601 CENTRAL AVE NE
+
501 CENTRAL AVE NE
RESPONSE TO SKETCH PLAT
COMMENTS

Integrated Design & Architecture
Meeting Date: March 20, 2024

MARCH 20, 2024
 SHEET 9 of 9

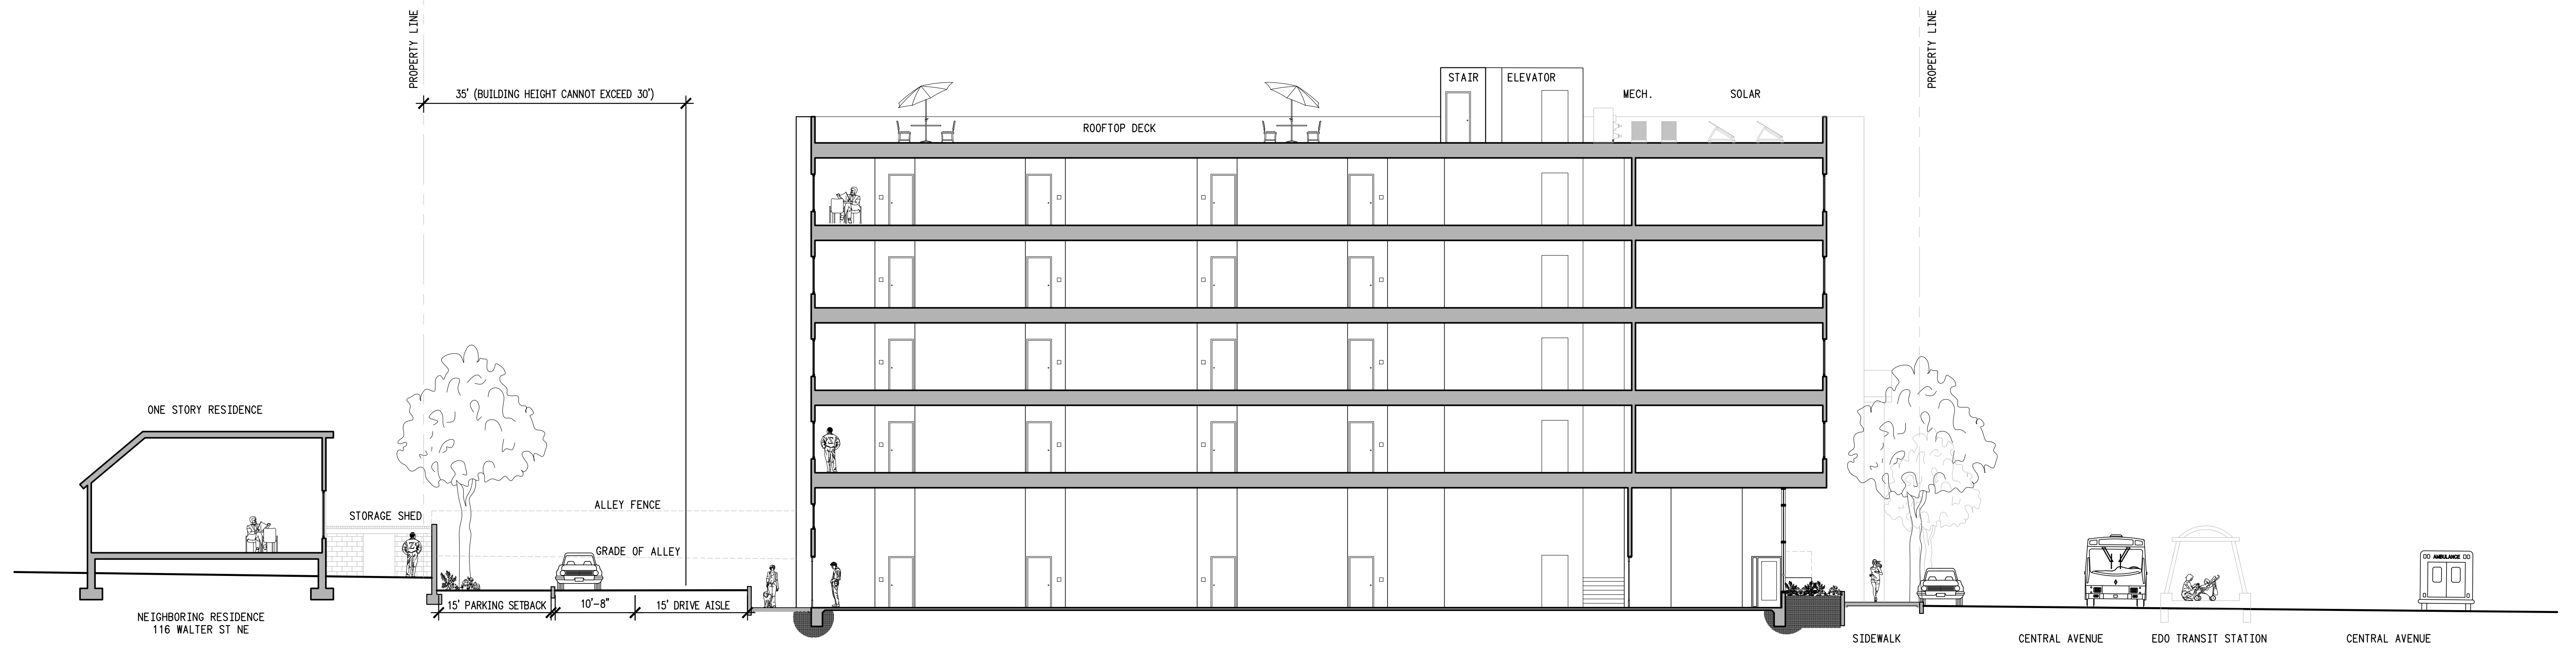
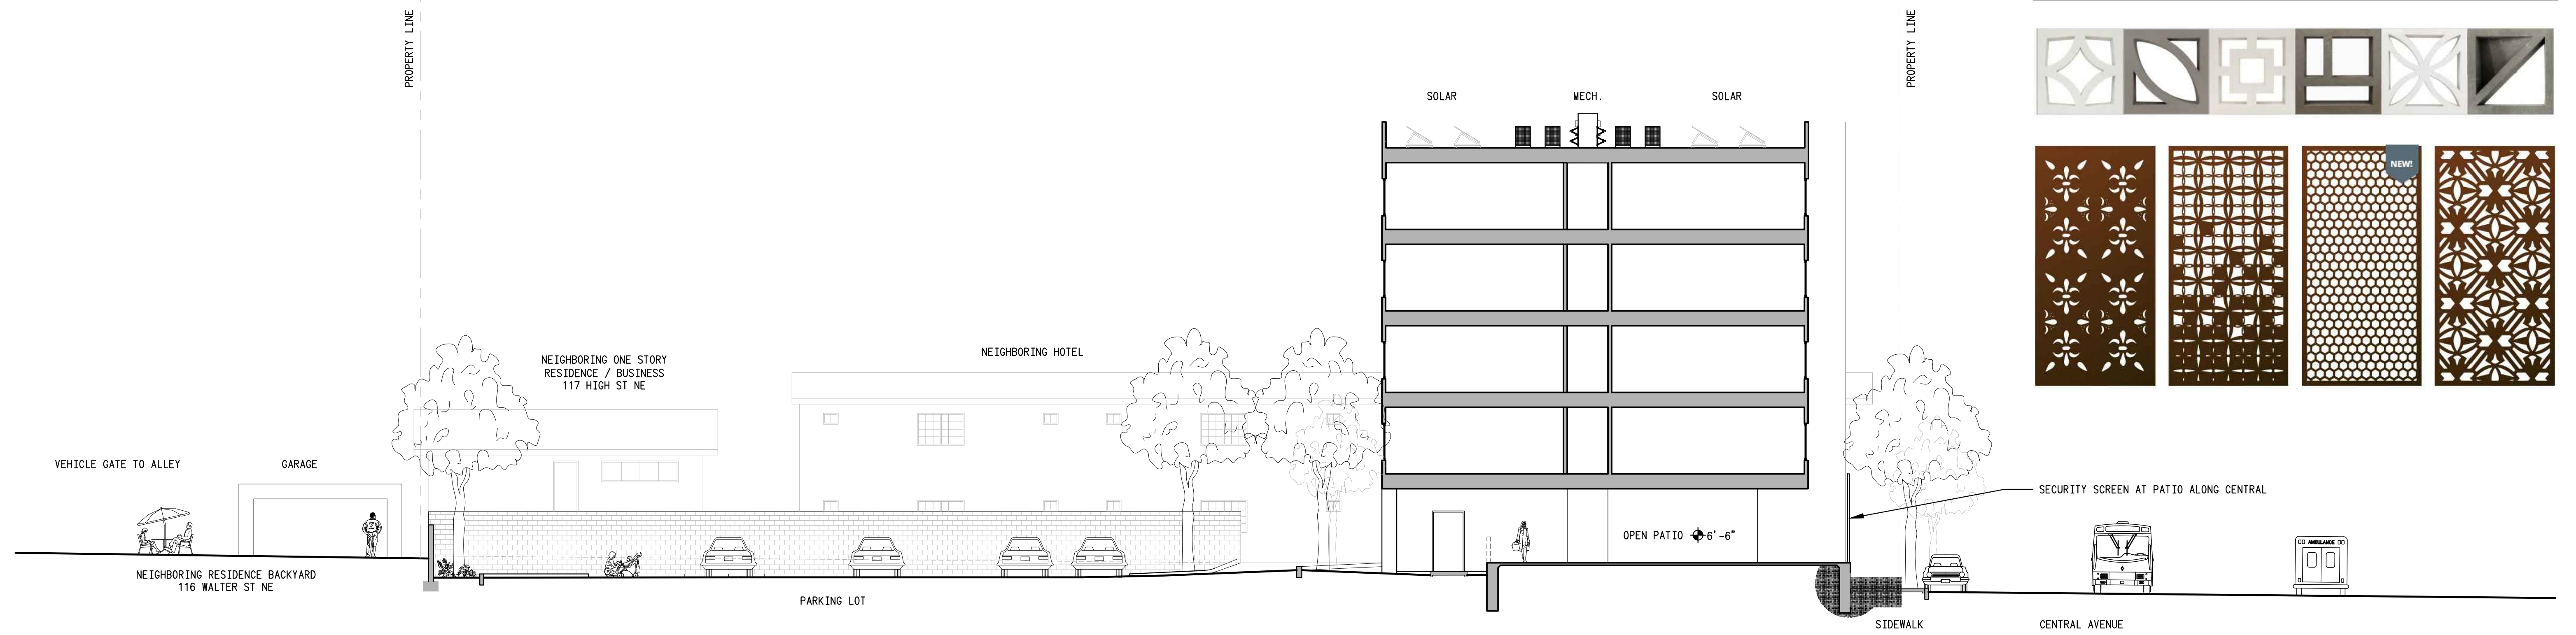
Sketch Plat Comment: “Requirements in section 5-9 in the IDo, neighborhood edges, would apply. Property is abutting R-1 to the north. Development within 50ft of a protected lot is limited to 30ft.”

Discussion: Previous discussion (3/6/24): IDA referenced 14-16-3-4(E)(5)(a) in correction to the comment that building height must step down to 30 ft. within 50 ft. of R-1. Conchetta agreed to look into this and confirm whether or not step down height was limited to 30 ft. within 35 ft. or 50 ft. of the building.

Question/Response: It is clear from 14-16-3-4(E)(5)(a) that our building height should only be restricted to 30 ft. within 35 ft. of R-1 because Neighborhood Edge provisions of height do not apply. We would like Cochetta to still confirm and amend the comment.

Question/Response: We are assuming our patio will be considered a “Covered Patio” per *Usable Open Space* definition. This patio will be open on two sides with a security screen along the side that is open to Central to keep the site secure, as the patio will be for tenant use only. This screen will provide visual, light, and air to pass through, meaning the patio will still be open on two sides. See below for examples of what this screen could look like.

Sketch Plat Comments: “Requirements in section 5-9 in the IDO, Neighborhood edges, would apply. Property is abutting R-1 to the north.” . . . “In addition, any parking or circulation area that is abutting a protected lot requires a 6ft opaque wall or fence.”

Question/Response: Building Height Stepdown requirements in Section 5-9 would not apply to either site because the CPO-4 overlay Building Height Stepdown overrides the requirements of 5-9. The parking lot would require a 15 ft. landscape buffer between the R-1 to the north of 601. We will need to request a variance to reduce this requirement so that our parking lot fits on the site.
